Subject: The Pagham Club 2 West Front Road Pagham PO21 4SY - P/2/22/DOC

Planning Application Reference: P/2/22/DOC

Proposal: Change of use of existing staff residential accommodation to be used as a separate unit of residential accommodation.

Condition 7 - Electric Vehicle Charging

Block Plan REV02

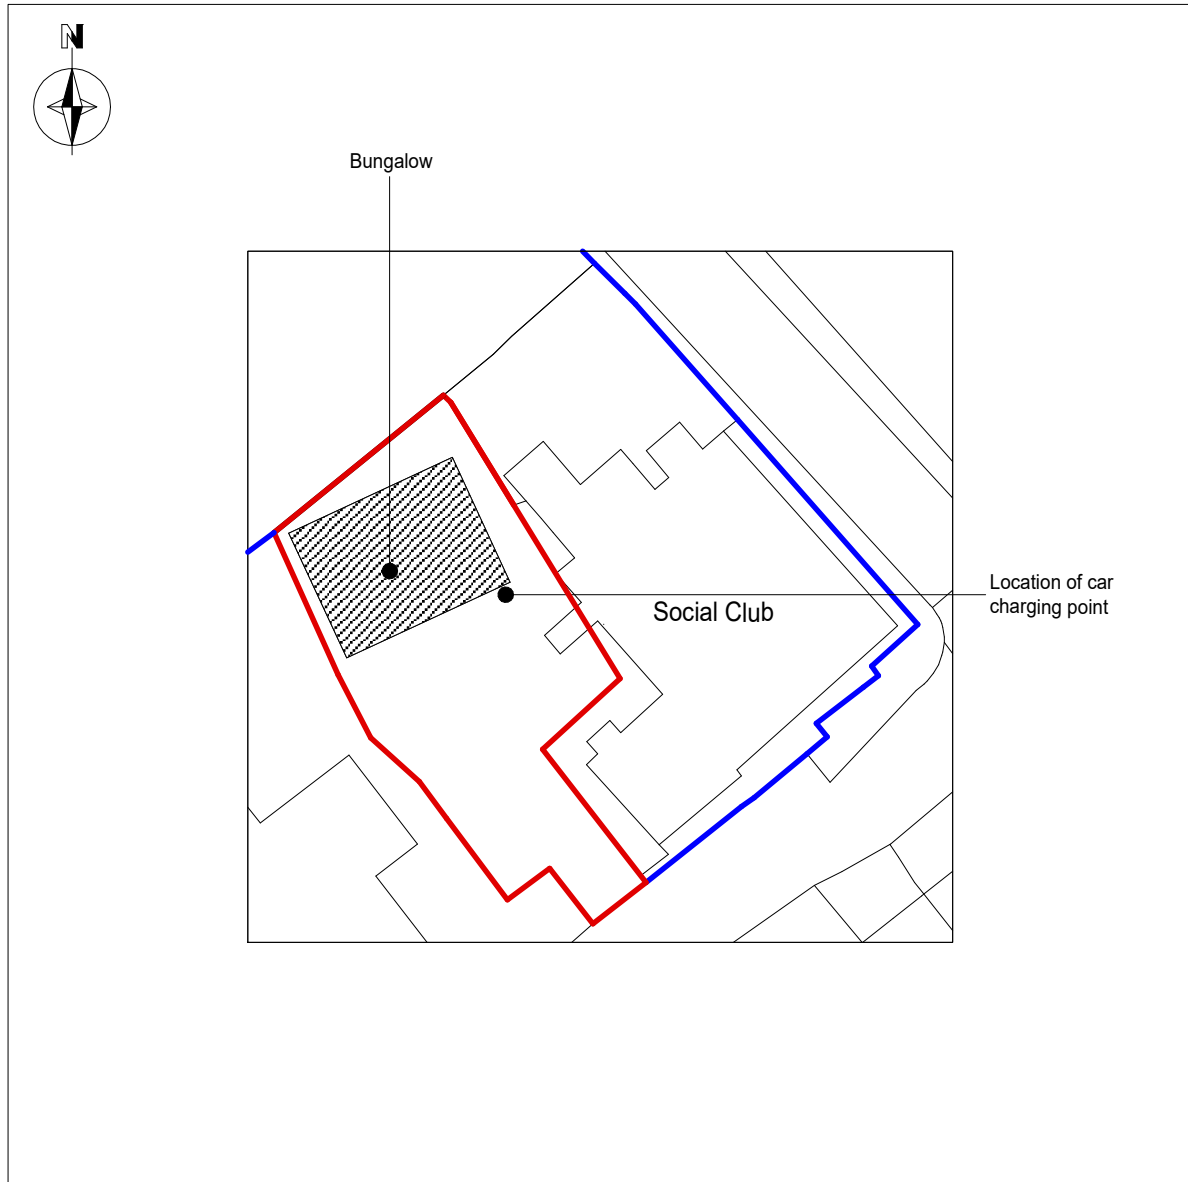
Having reviewed the documents entitled 'Block Plan Rev02', 'car charger type' and 'photo car charger in place', I can confirm that the electric vehicle charging arrangement is satisfactory for the proposed development. I therefore recommend the condition may be discharged.
